POWERHOUSE PARRAMATTA

DESIGN INTEGRITY REPORT

This report outlines the design integrity process and review that has occurred to support a modification application for Powerhouse Parramatta SSD-10416 for amendment of the pavilion roof and fit out and use of St George's Terrace.

Proposed Rooftop Pavilion - Aerial View

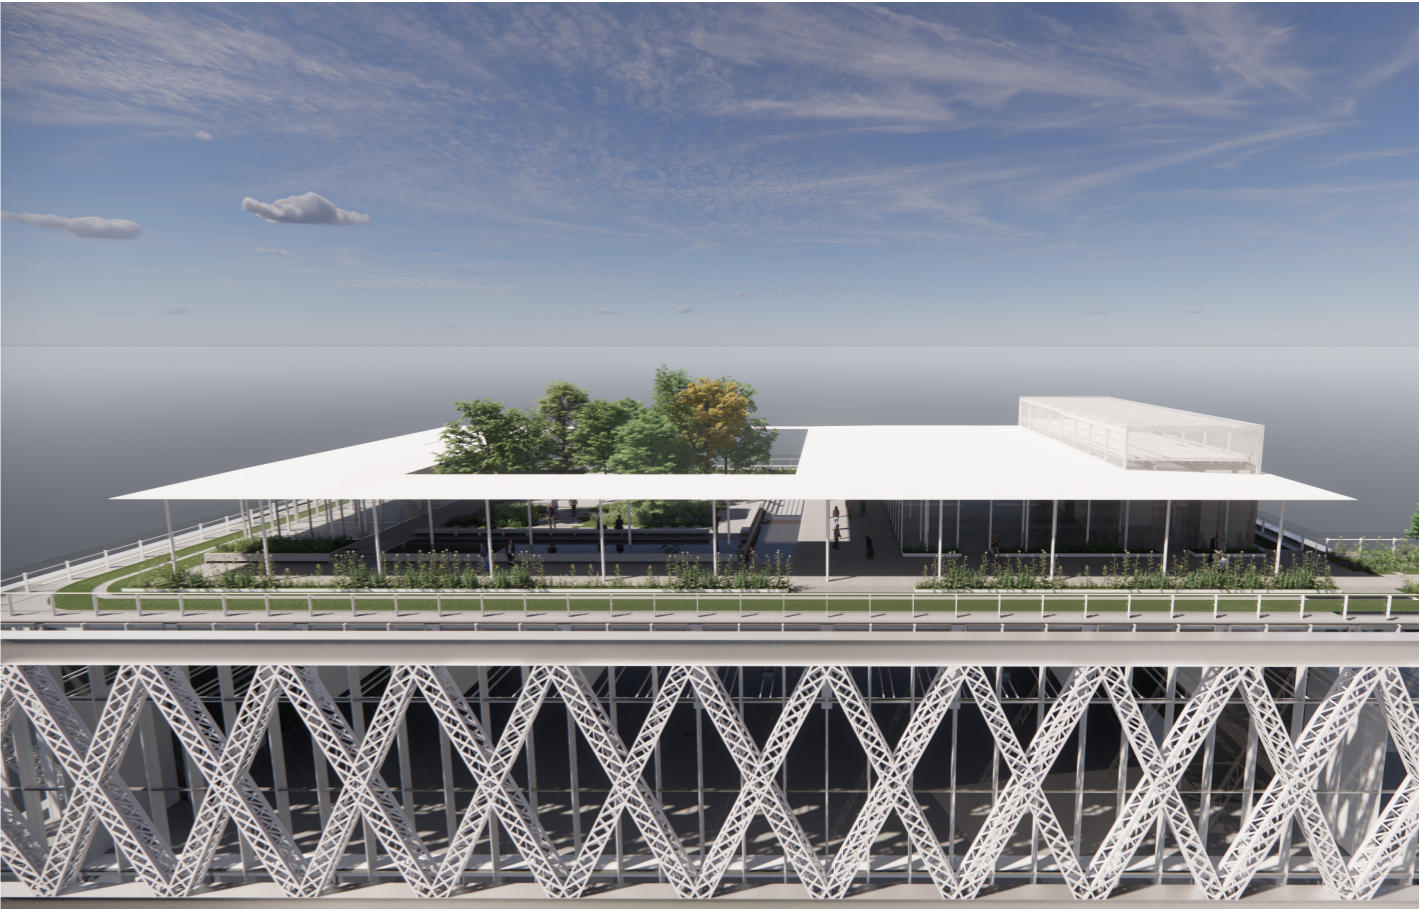
The rooftop terrace pavilion roof structure is proposed to be increased in size in order to create more functional space atop the Eastern Building. The expansion of the pavilion will enable greater all-weather use of the rooftop allowing the space to become more functional within the Powerhouse program.

The Panel has reviewed the proposed design for the expanded pavilion and notes that:

- The structure remains well below the permissible height limit;
- The increase of the pavilion will enable it to service a wider array of functions;
- The expanded roof structure is light-weight and minimal in design and in-keeping with the remainder of the building; and
- The proposal represents a considered development of the design.

1 PROPOSED PLAN - GROUND FLOOR
 1 : 100

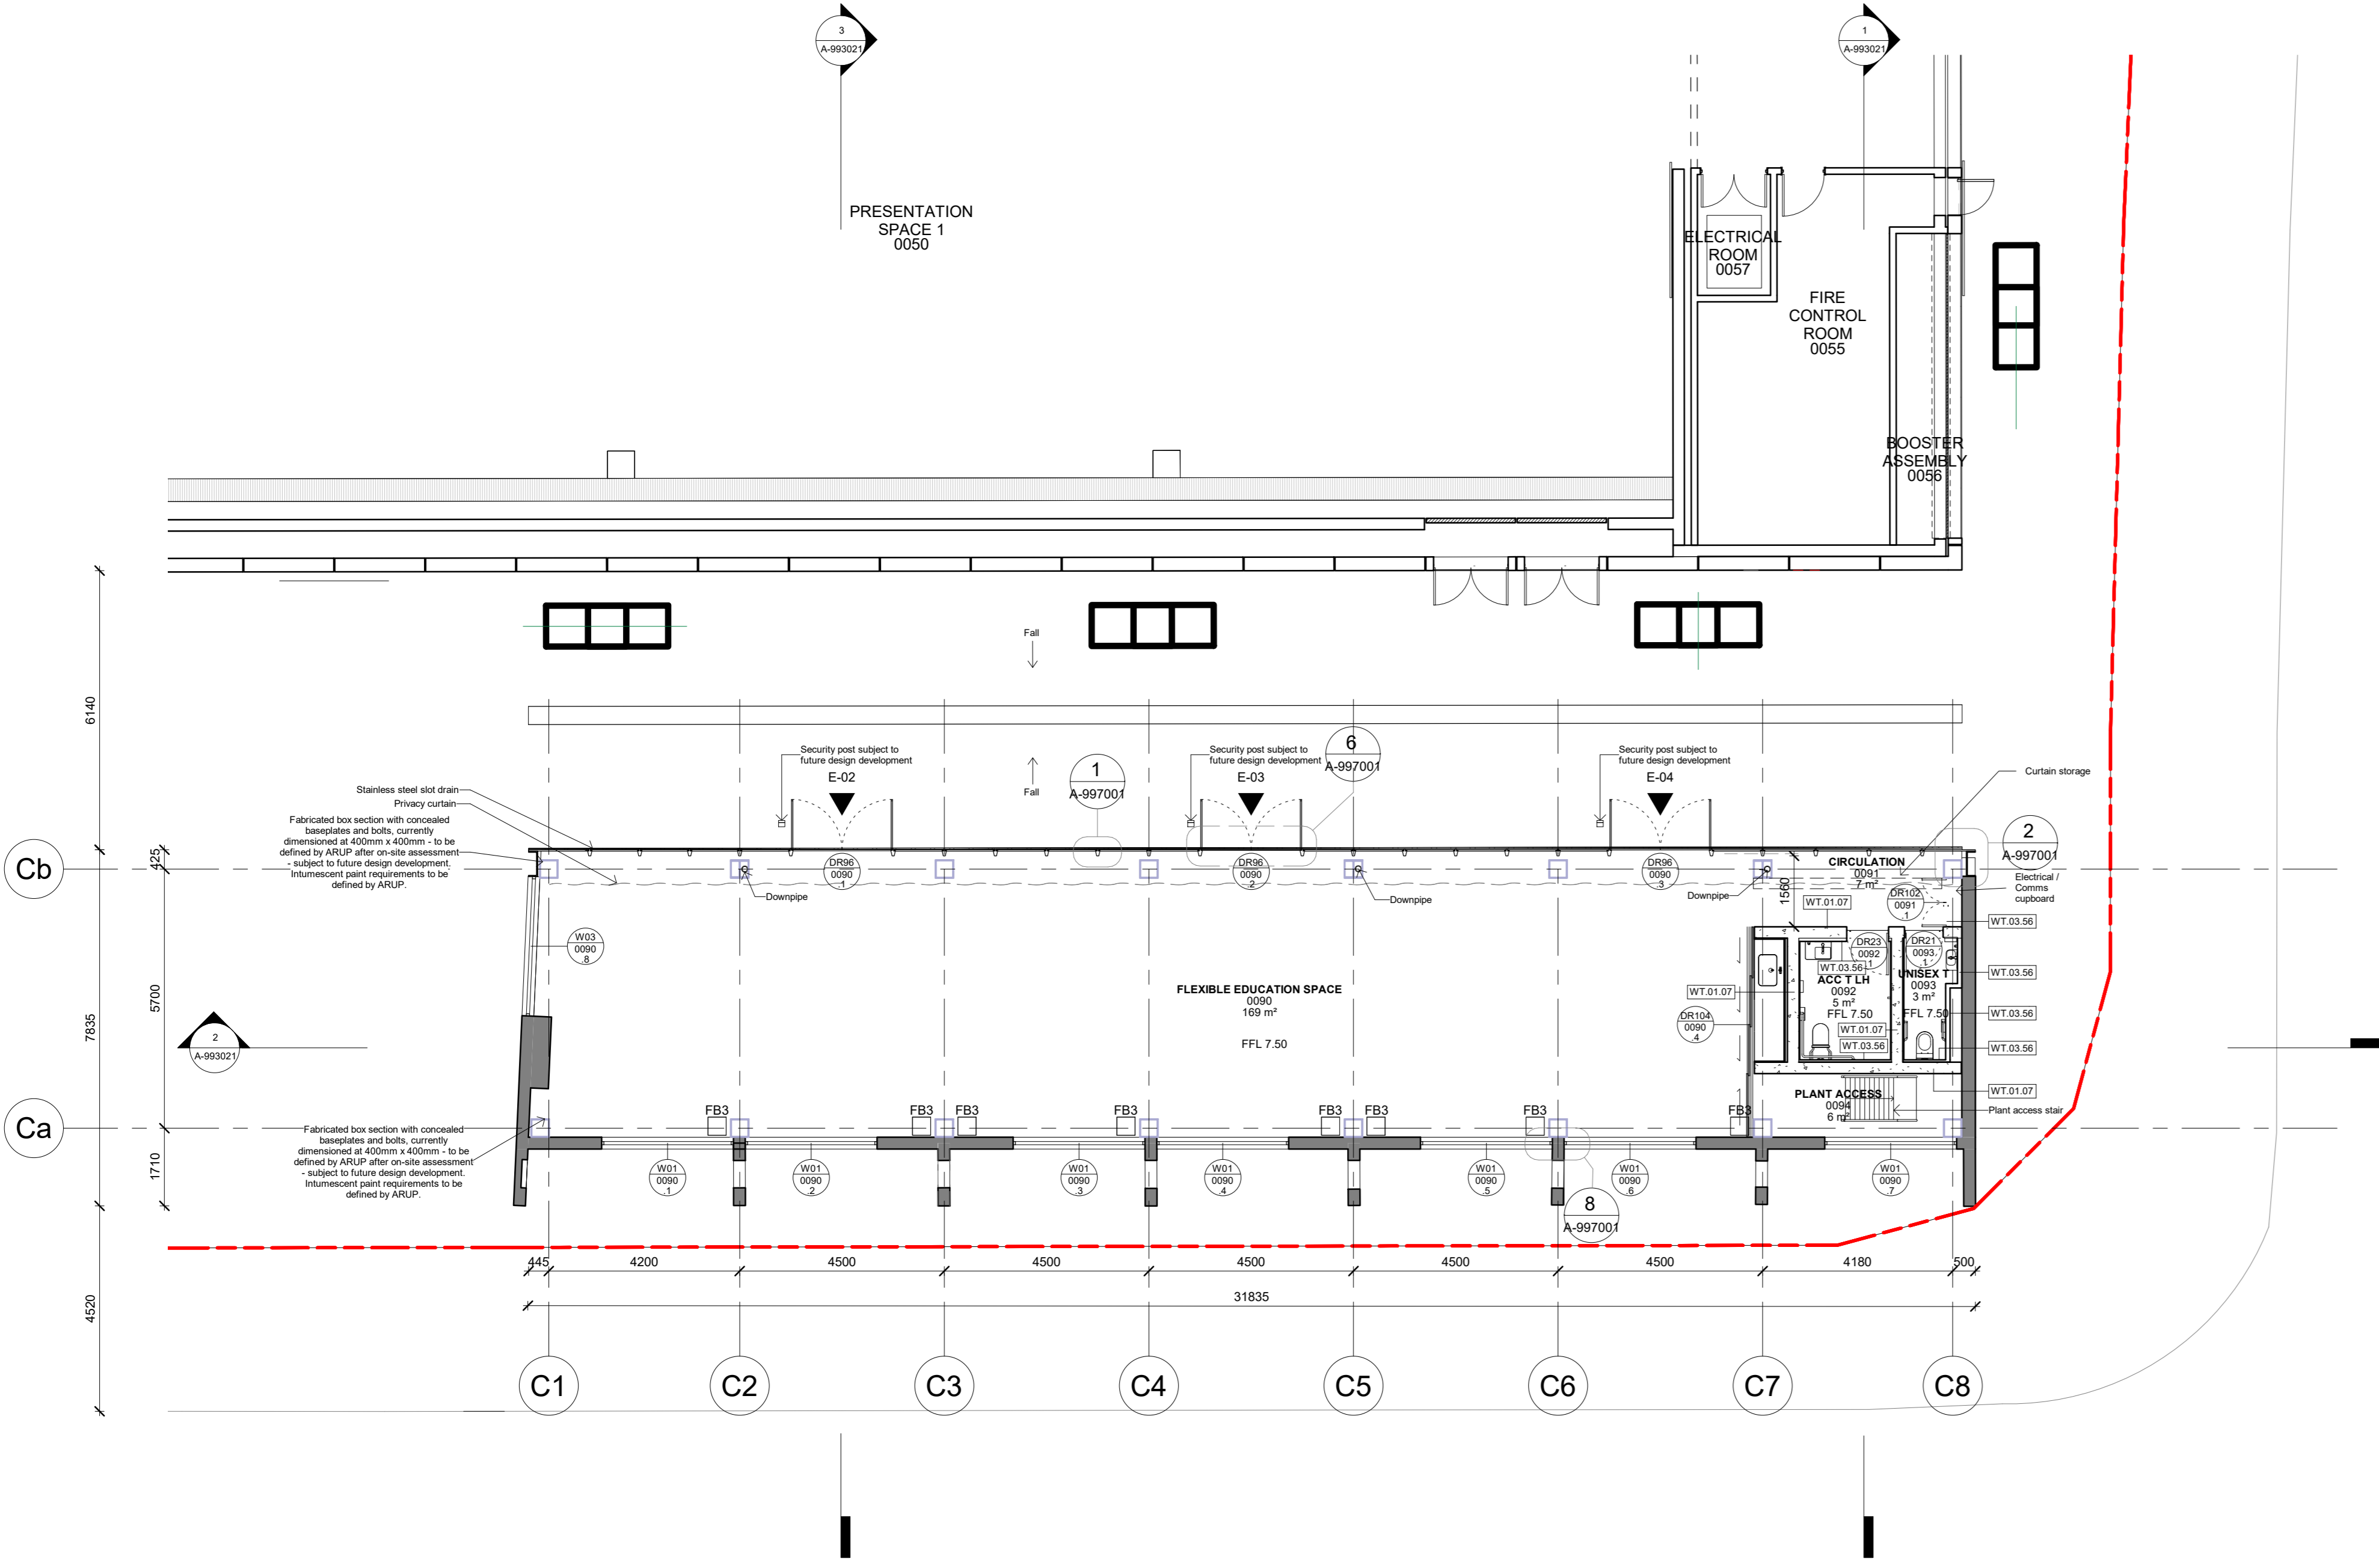
The proposal to transform the terrace to a flexible, double height space is considered in-keeping with the ethos of the remainder of the Powerhouse Parramatta design. A minimal design palette mirrors the eastern and western museum buildings and creates a functional adaptive reuse of the heritage structure.

The Panel note that the structural steel support will interpret the original terrace party wall lines and a glazed and operable northern façade will create activation between the terrace and PS1. Further the replacement of existing (non-heritage) doors and windows along Phillip Street with fixed glazing will activate the streetscape with views into the museum activities hosted within.
